Ref: 6/2024/1044/LB & 6/2024/1043/HOUSE
Date: 24/06/2024

HISTORIC BUILDINGS AND CONSERVATION ADVICE

RE: 13 Fore Street Hatfield AL9 5AN

This application is for the replacement of 7 sliding sashes to existing frames and the full replacement of 2 sash windows. Replacement of 4 windows casement eaves only to existing frames and the full replacement of 6 casement windows and the full replacement of 2 doors.

EXISTING WINDOW DETAIL ITEM W08 - SCALE 1:10

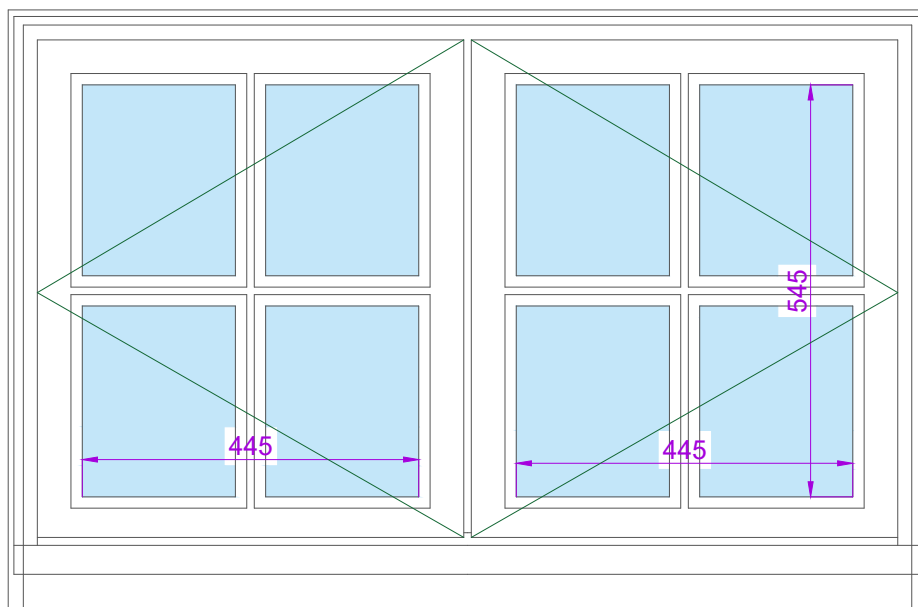
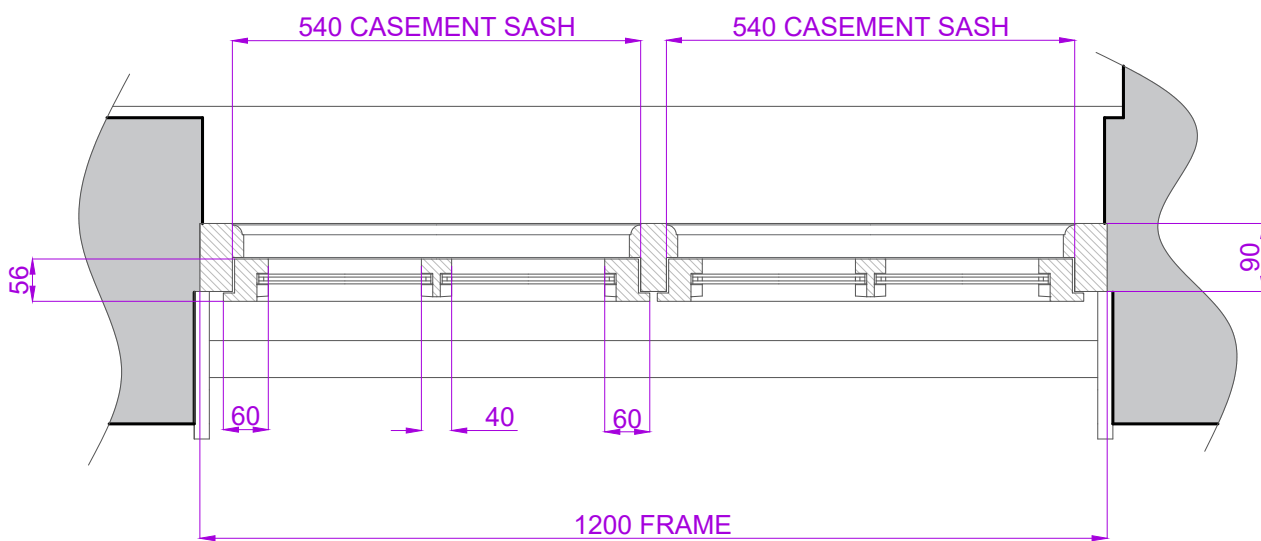
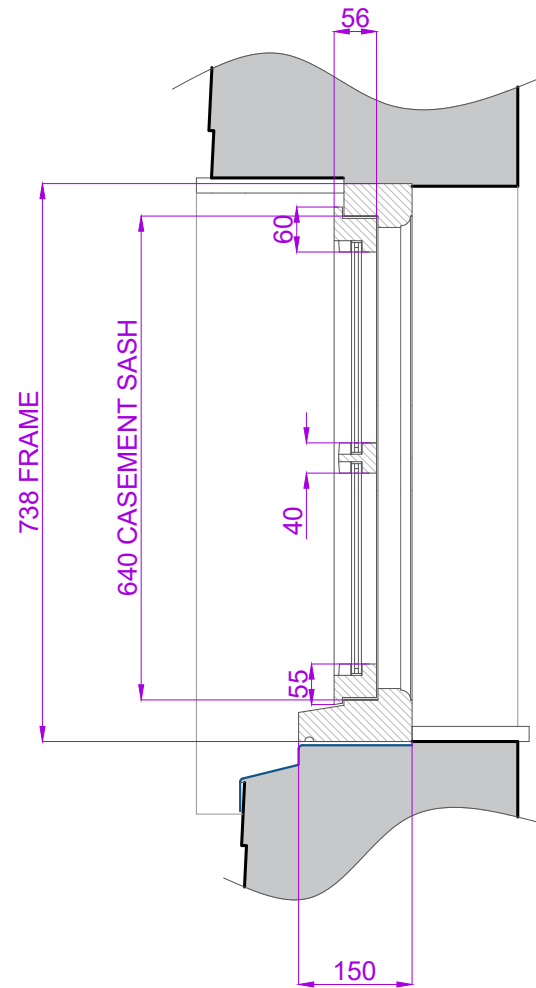
There would be no objection to the replacement of uPVC or modern stormproof casement windows with more appropriately detailed windows; this would be considered an enhancement. Similarly, item 9 is missing a casement and installing a casement would be supported, subject to the details.

ITEM W01

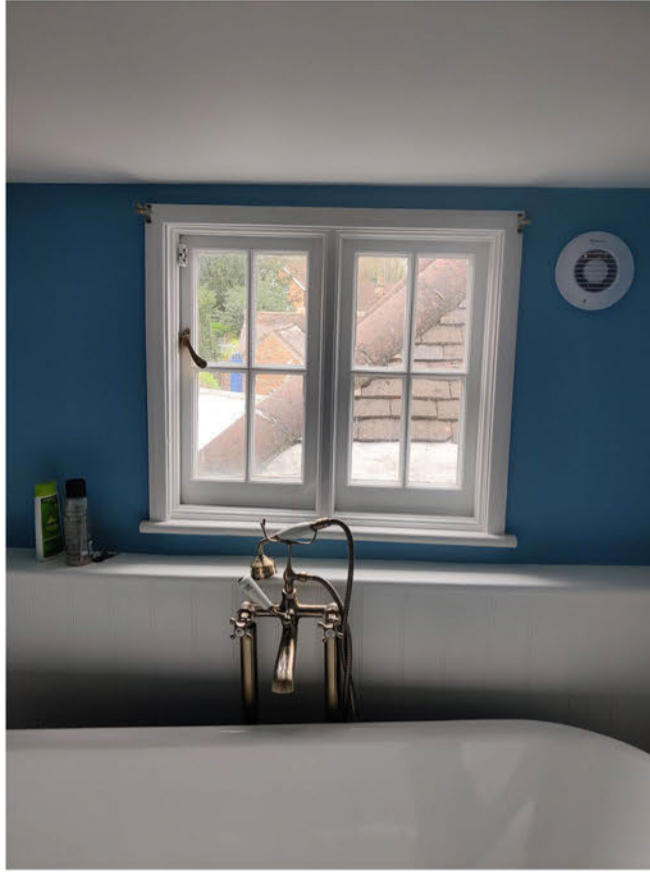
Evidently, some of the window frames are in a poor state of repair, particularly items 01 and 02. However, it is unclear why the windows and doors throughout the property require wholesale replacement. The proposed wholesale replacement has the potential to result in the loss of historic fabric. There are limited close-up photographs of all the items, but in the photographs provided most windows and doors appear to be in a good or repairable condition. If the windows and doors (that make a positive contribution) are beyond economical repair, it should be clearly demonstrated through a comprehensive condition survey, and they should be replaced with accurate copies.

PROPOSED WINDOW DETAIL ITEMS W01 & W02 - SCALE 1:10

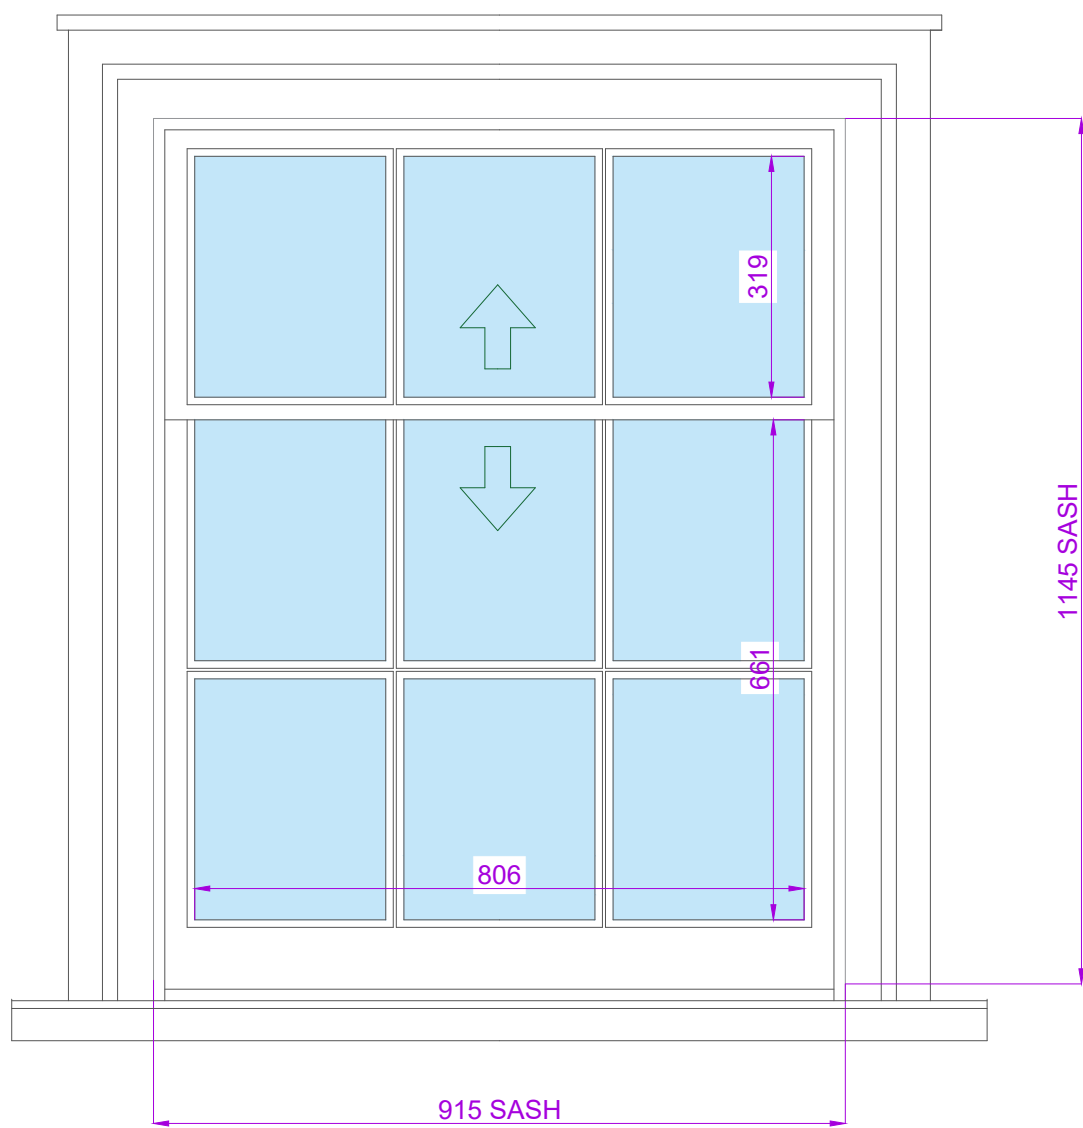
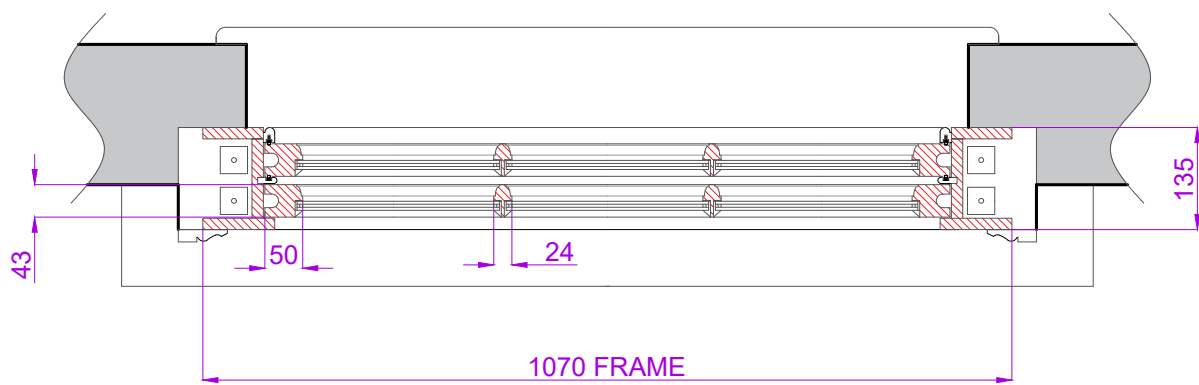
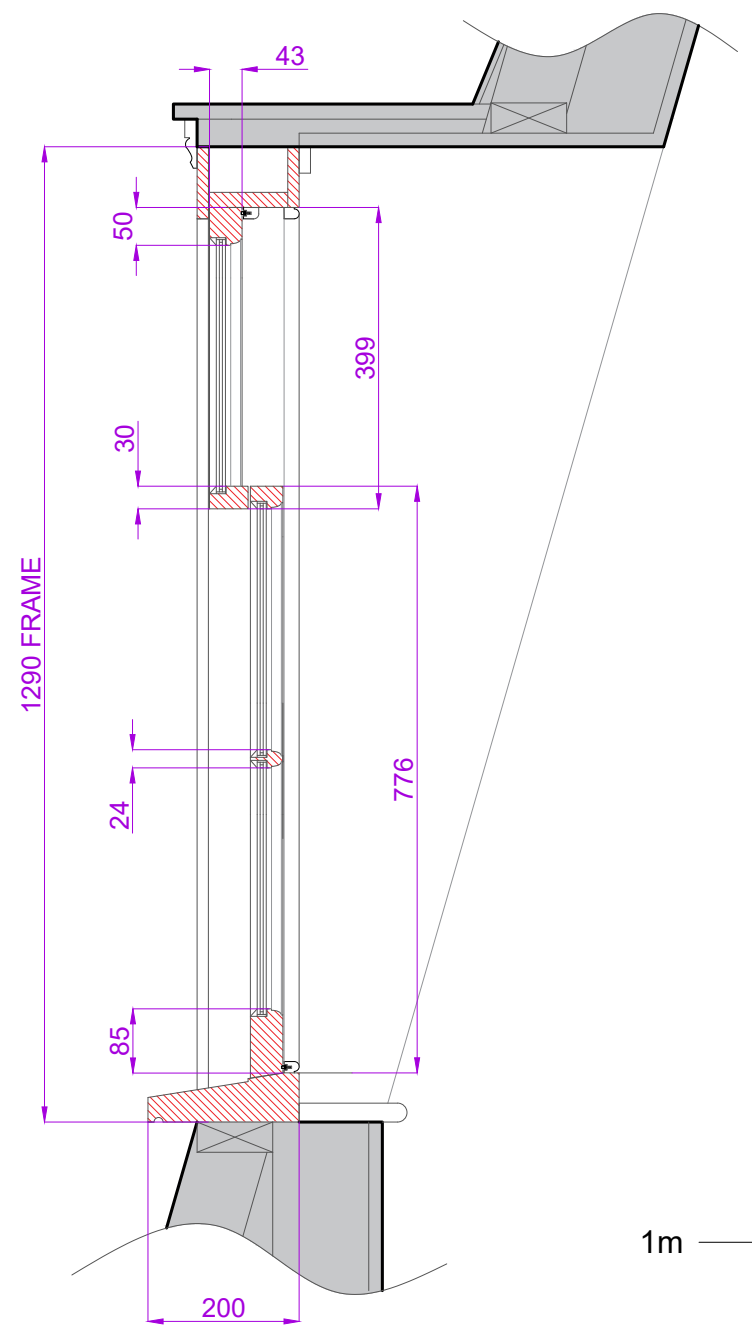
Notwithstanding concerns such concerns, the proposed replacement windows would have slightly thicker glazing bars than some of the existing windows and would be double glazed. The differing appearance and character, when compared to the existing windows, could detract from the architectural interest of the listed building.
